The Gardens Trust  
70 Cowcross Street, London EC1M 6EJ  
Phone: (+44/0) 207 608 2409  
Email: [enquiries@thegardenstrust.org](mailto:enquiries@thegardenstrust.org)  
[www.thegardenstrust.org](http://www.thegardenstrust.org)

5<sup>th</sup> May 2020

Ref : 18/00825/HYBRID – Amendments - A hybrid planning application; Heyford Park, Camp Road, Upper Heyford, Bicester OX25 5HD

The GT/OGT wish to lodge a holding **objection** to the amended proposals, including re-location of sports development and 30m high observation tower with zip-wire, pending further details and clarification of the impacts on views and the setting of the Grade I Rousham landscape.

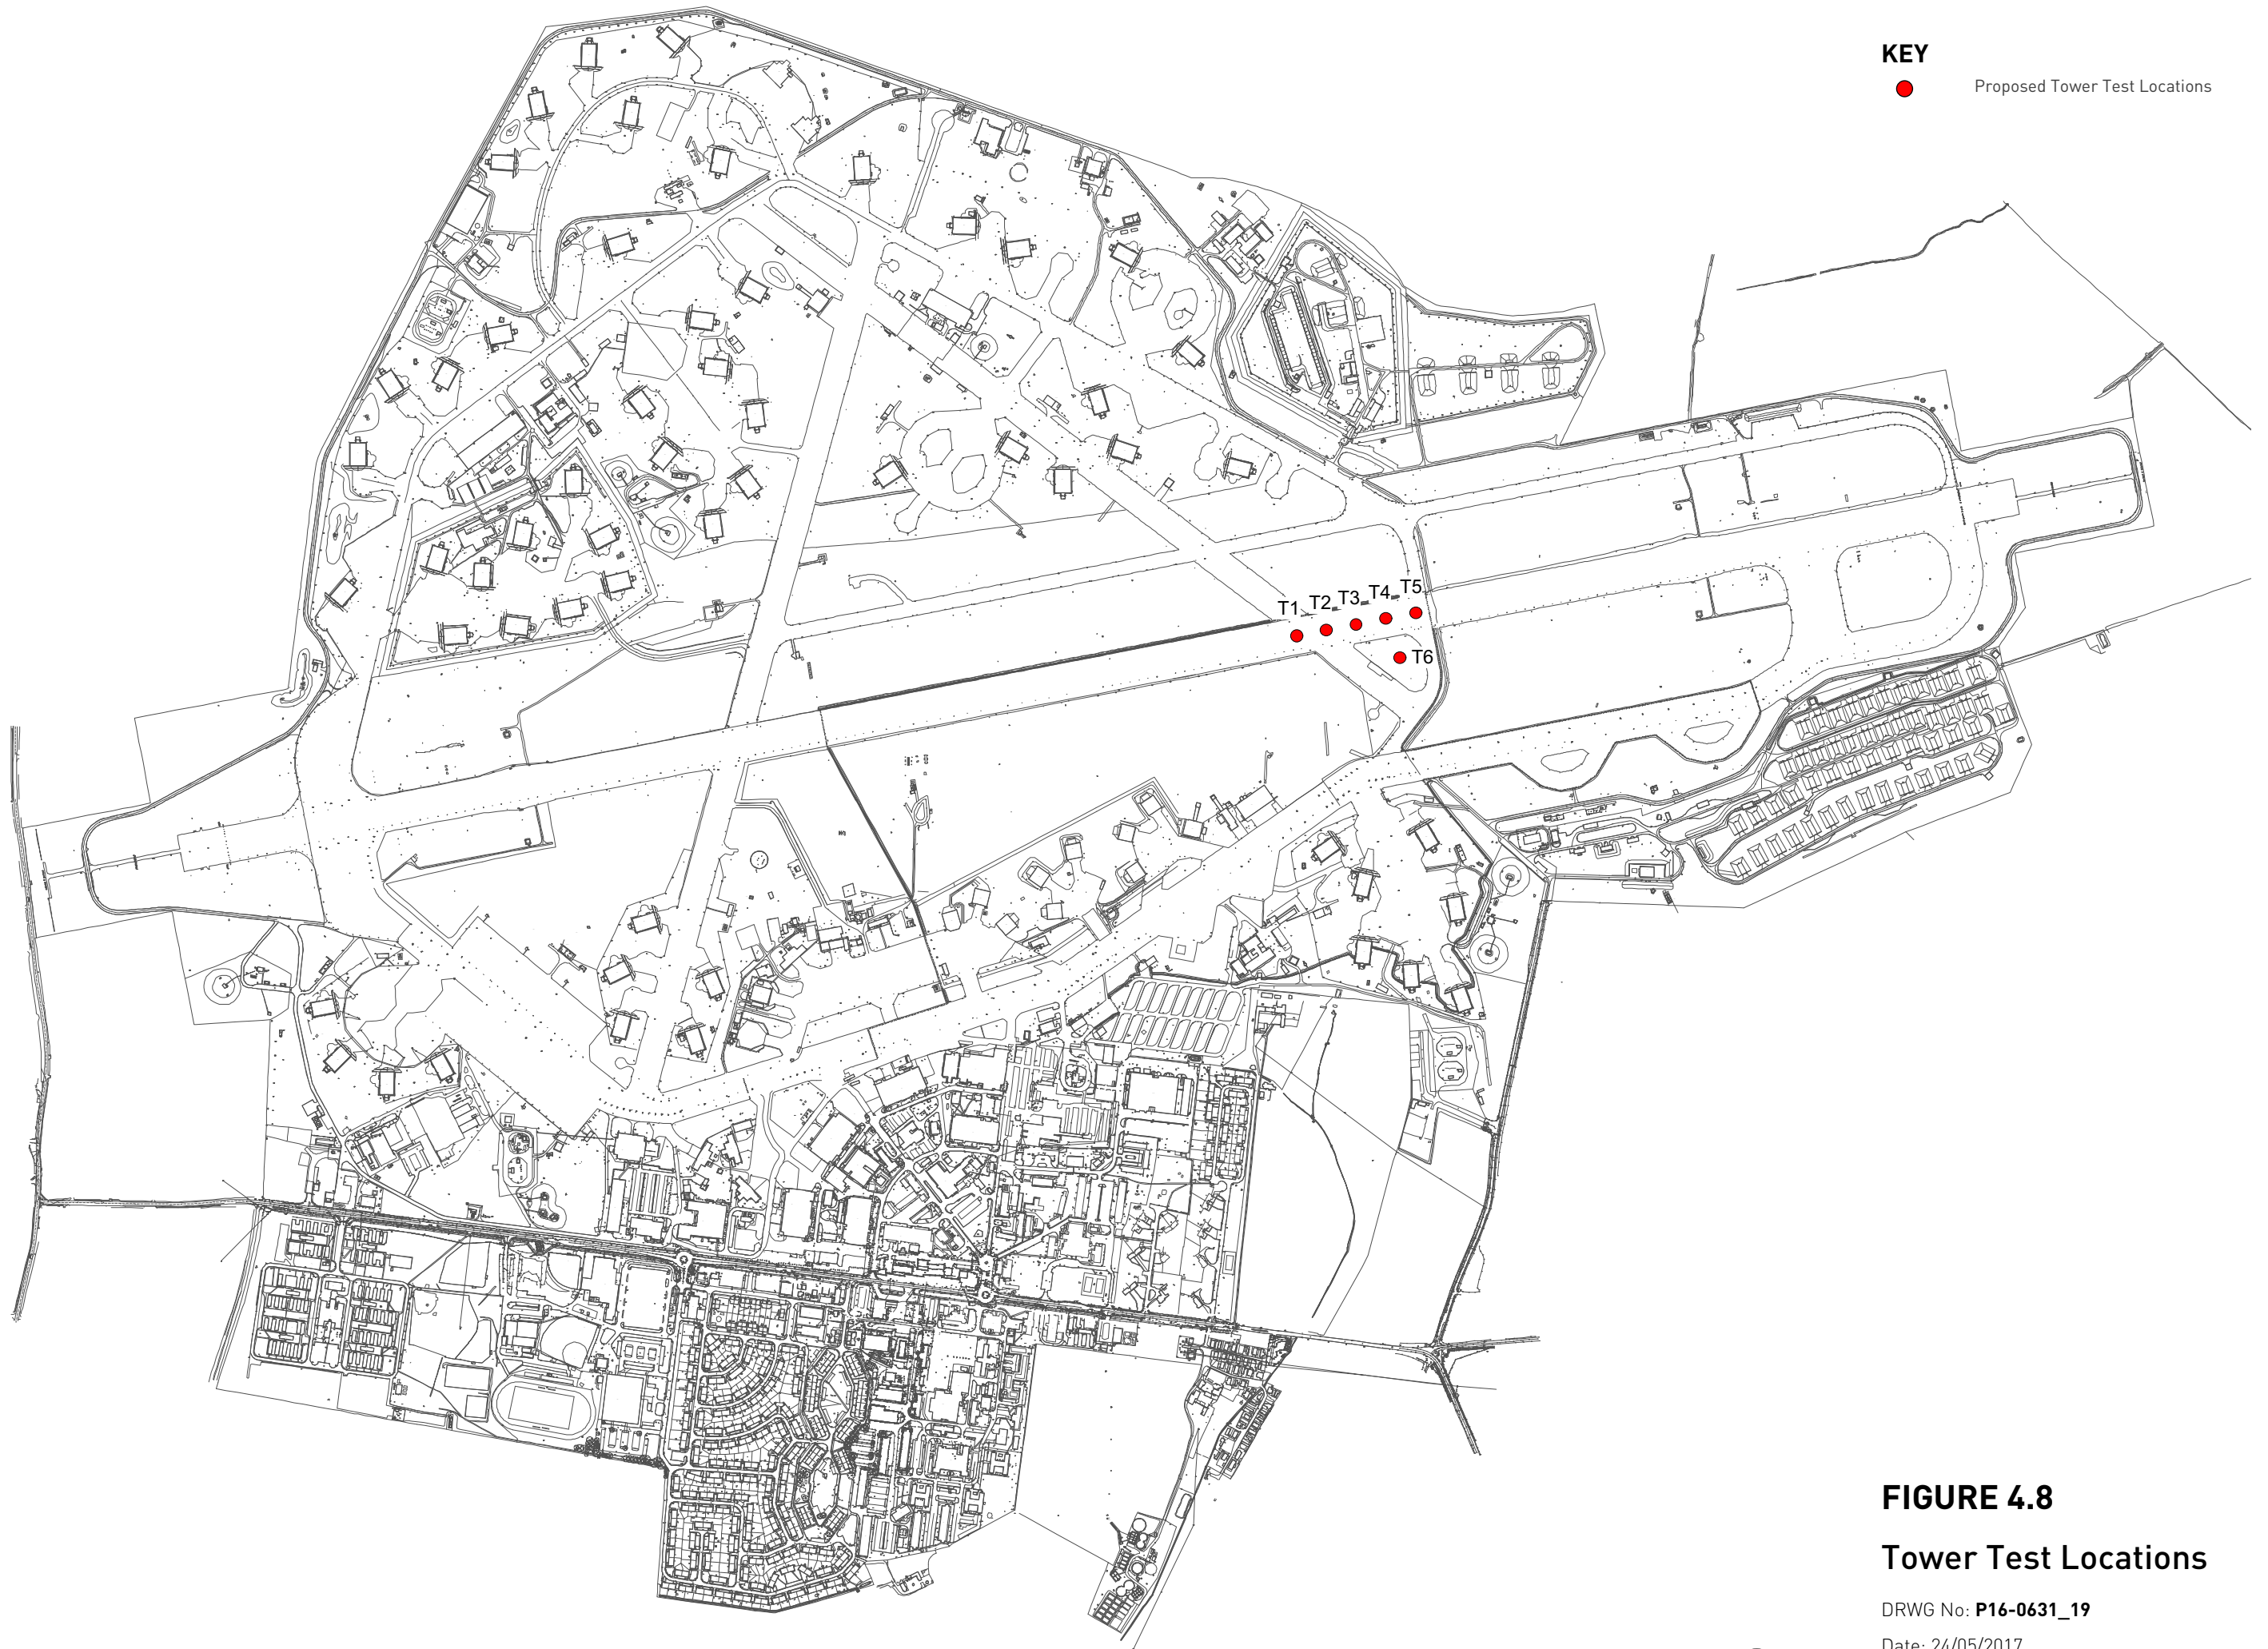
Cumulative impacts of features such as towers on the skyline can impact negatively and harm views. Your officers will be familiar with Historic England's The Setting of Heritage Assets, Historic Environment Good Practice Advice in Planning Note 3 (Second Edition), pub 2<sup>nd</sup> Dec 2017, Part I – Settings and Views. 'When assessing any application for development which may affect the setting of a heritage asset, local planning authorities may need to consider the implications of cumulative change.' (p2) Also relevant : (p5) 'development further afield may also affect significance, particularly where it is large-scale, prominent or intrusive. The setting of a historic park or garden, for instance, may include land beyond its boundary which adds to its significance but which need not be confined to land visible from the site, nor necessarily the same as the site's visual boundary' and lastly (p12) 'Cumulative assessment is required under the EU Directive on EIA. Its purpose is to identify impacts that are the result of introducing the development into the view in combination with other existing and proposed developments.'

The LVIA should be revised and expanded to identify, assess and illustrate impacts from key viewpoints identified in the Rousham Conservation Area Appraisal, Para 9.2 (September 2018), and photomontages provided without tree leaf cover, of development over 10.5m (to comply with NPPF Para 189). Such view-points include from the Horse & Lion statue on the north of the Bowling Green, the Dying Gladiator above Praeneste, as well as from Townsend's Temple and various view points along the riverside walk.
